**Planning Department
Transportation Development Services**

Re: Wendy's, 3601 4th St. NW
Traffic Circulation Layout
Architect's Stamp dated 07-14-14 (G14-D031)

Re: Wendy's, 3601 4th St NW
Traffic Circulation Layout
Architect's Stamp dated 6-26-14 (G14-D031)

EXISTING/DEMOLITION SITE PLAN
ROTATED 10.25°
1" = 20'-0"

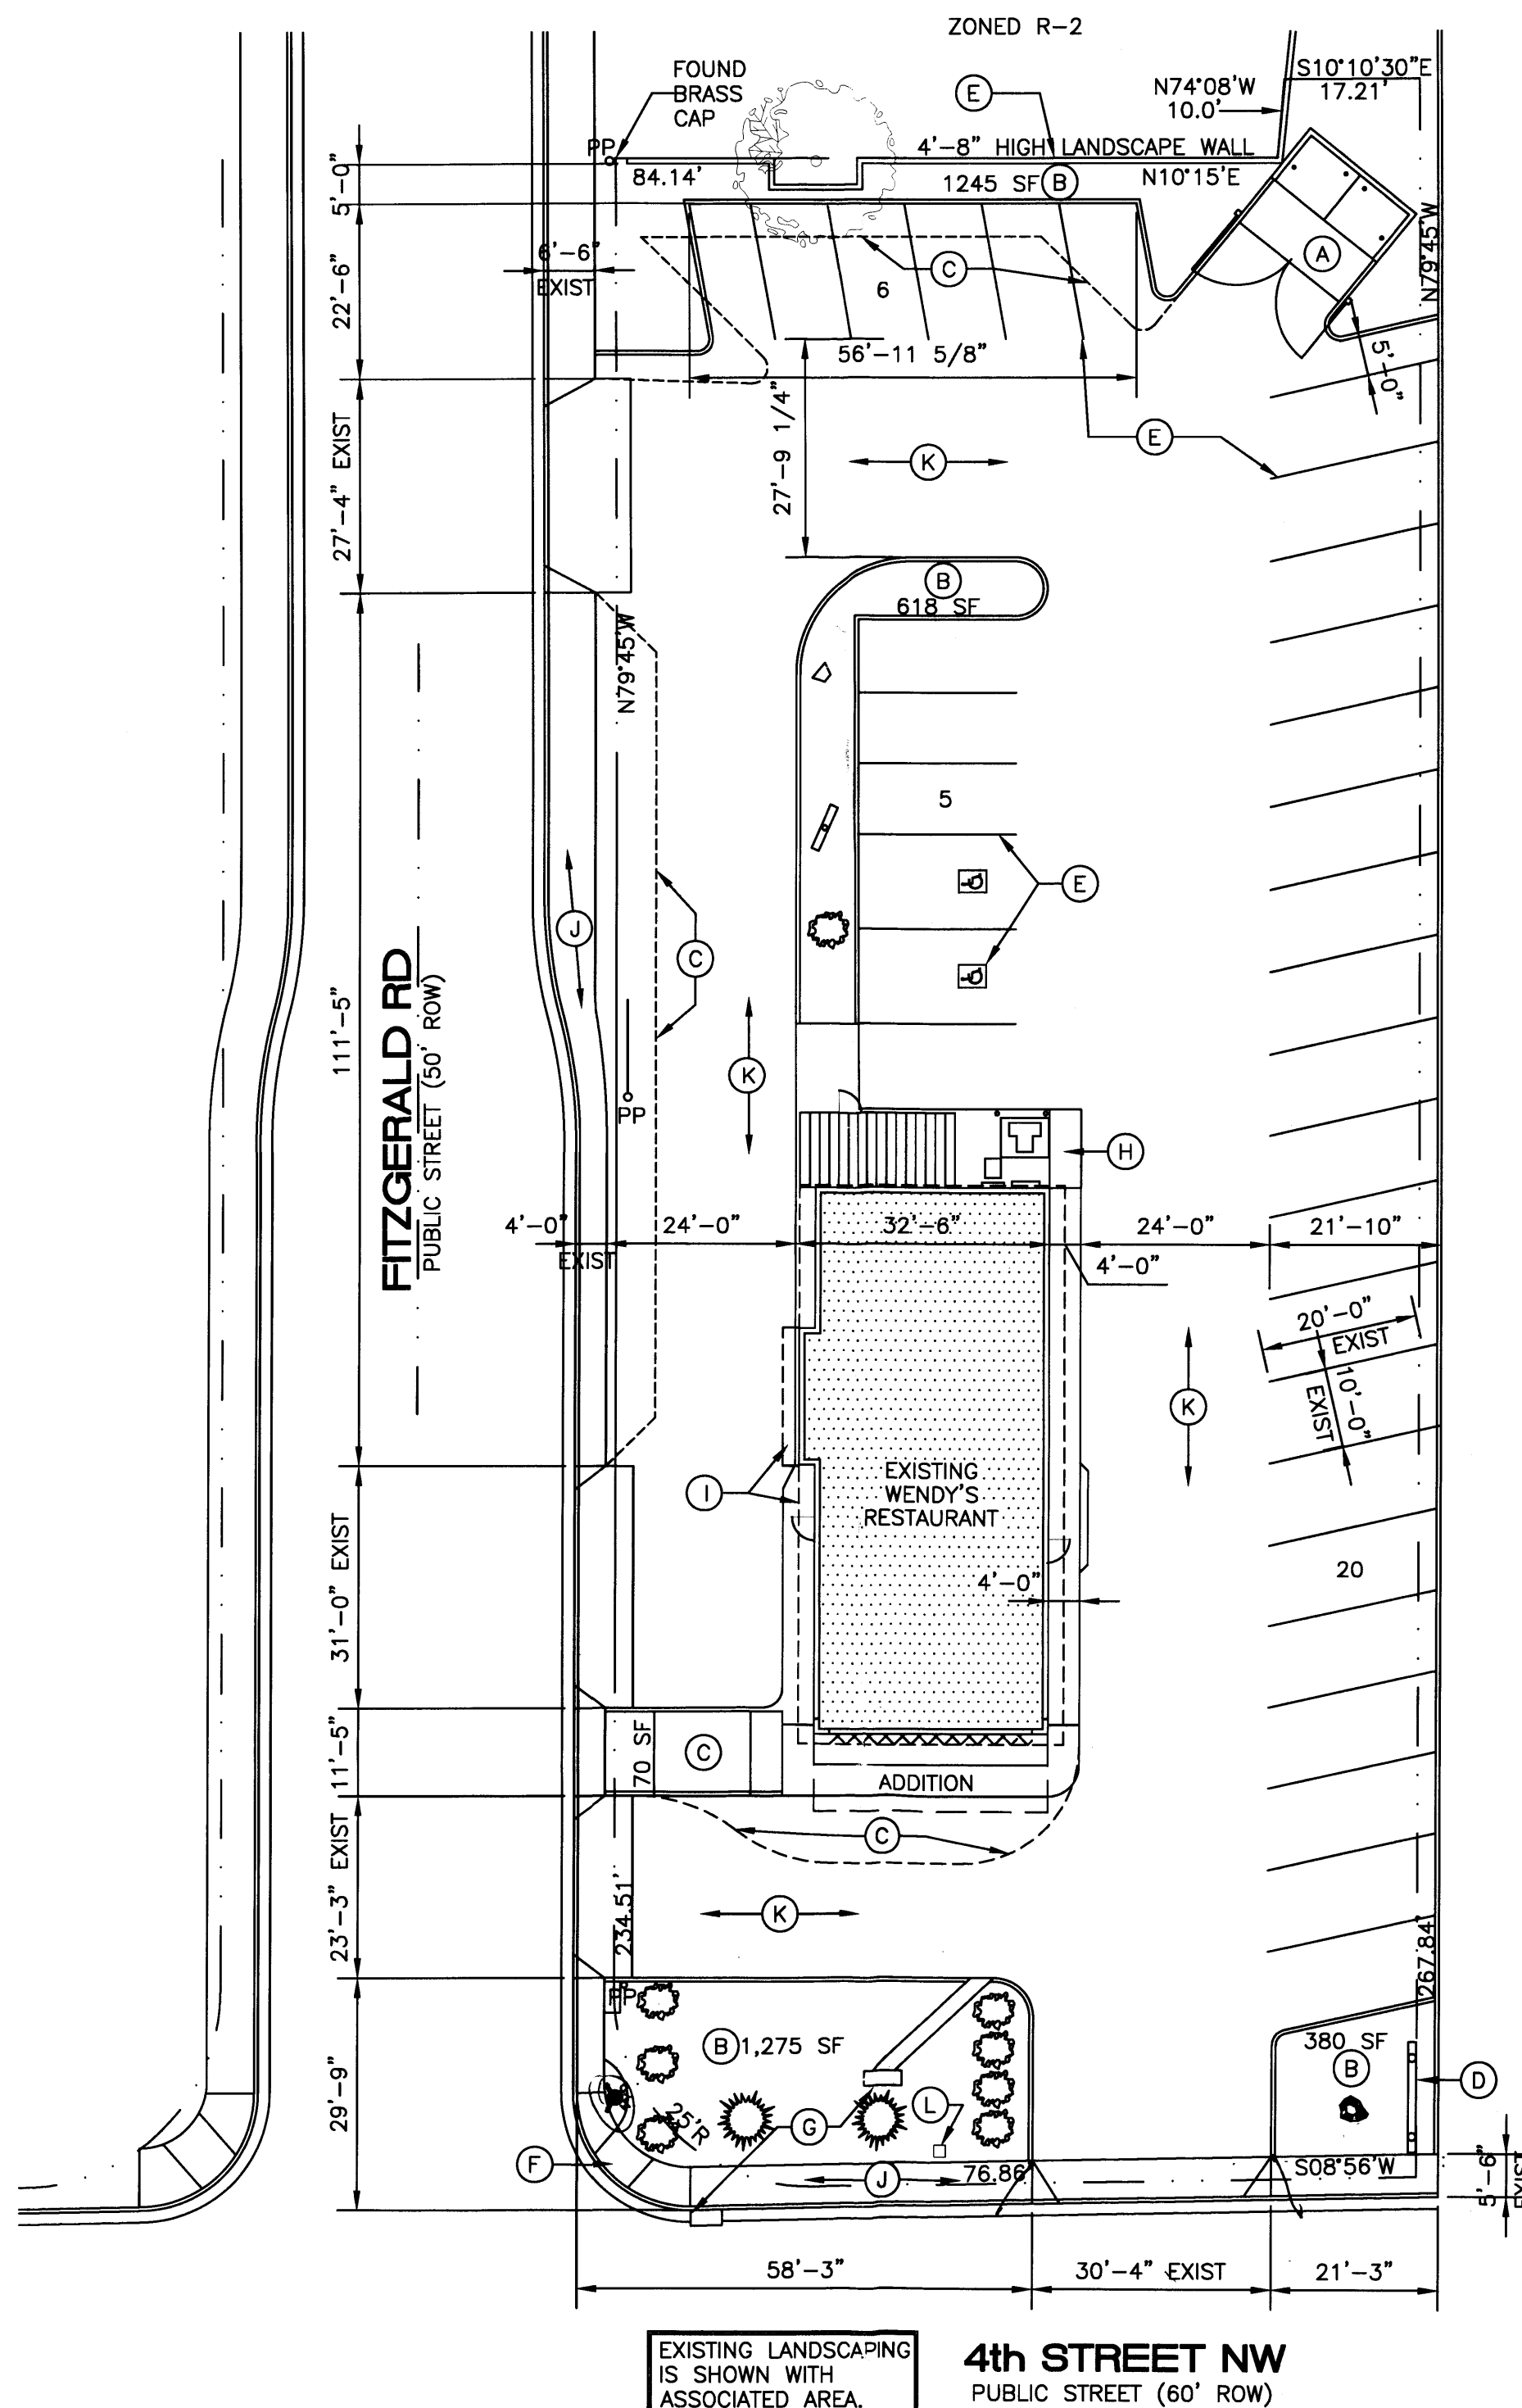
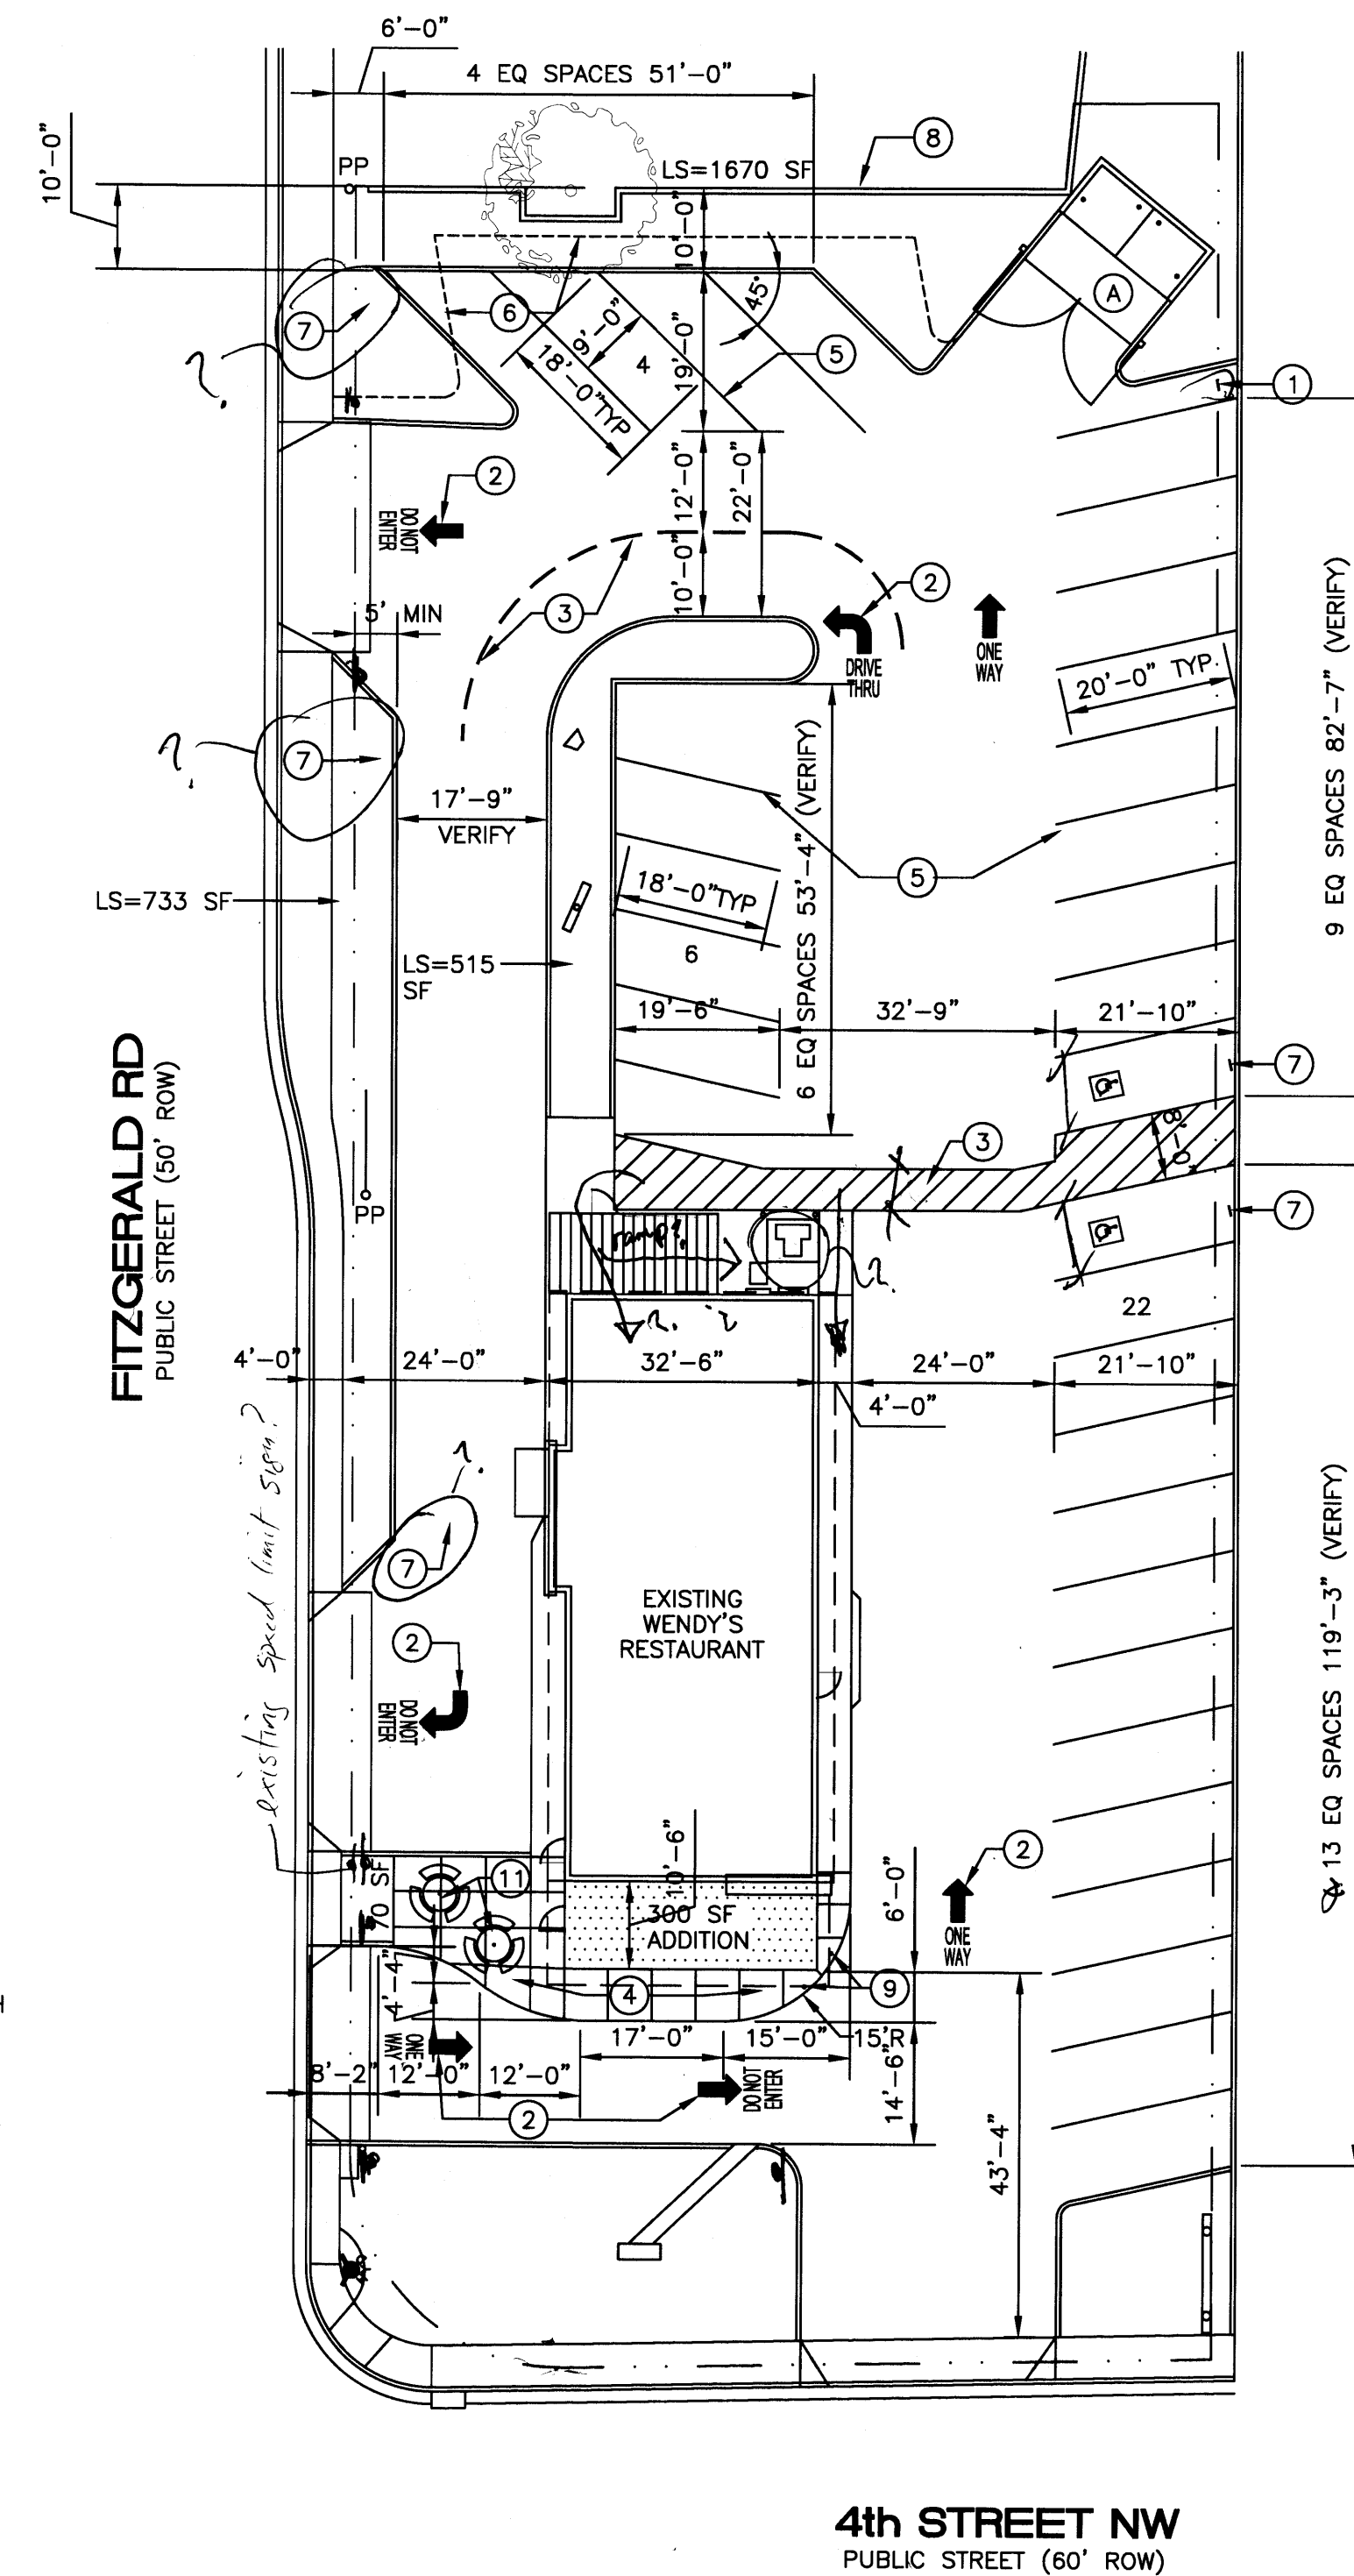
- ①. Please list the width and length for all parking spaces.
2. ✓ Please show a vicinity map.
- ③. The handicap accessible spaces must be a minimum of 8.5 feet in width.

4. ✓ The handicap accessible spaces must include an 8-foot wide van access aisle; all other aisles should be 5 feet in width.
5. ✓ Please provide a detail of the handicap accessible parking signage

- ⑥. Provide a heavy vehicle pathway on the plan.
7. ✓ Please include two copies of the traffic circulation layout at the next submittal.
8. ✓ Show the pedestrian pathway and ADA access to the building including all ramps.

9. ✓ How will ADA access be taken to the entrance of the building? The door appears to swing in the path way.
10. Please provide an easement for any sidewalk within the right-of-way.

11. ✓ Please provide approvable signage and striping i.e. one-way and do not enter.
12. ✓ Please remove non applicable note "7" from the TCL plan.
13. ✓ We suggest that the parking on the west end of the property be changed to compact parking to widen the drive aisle.
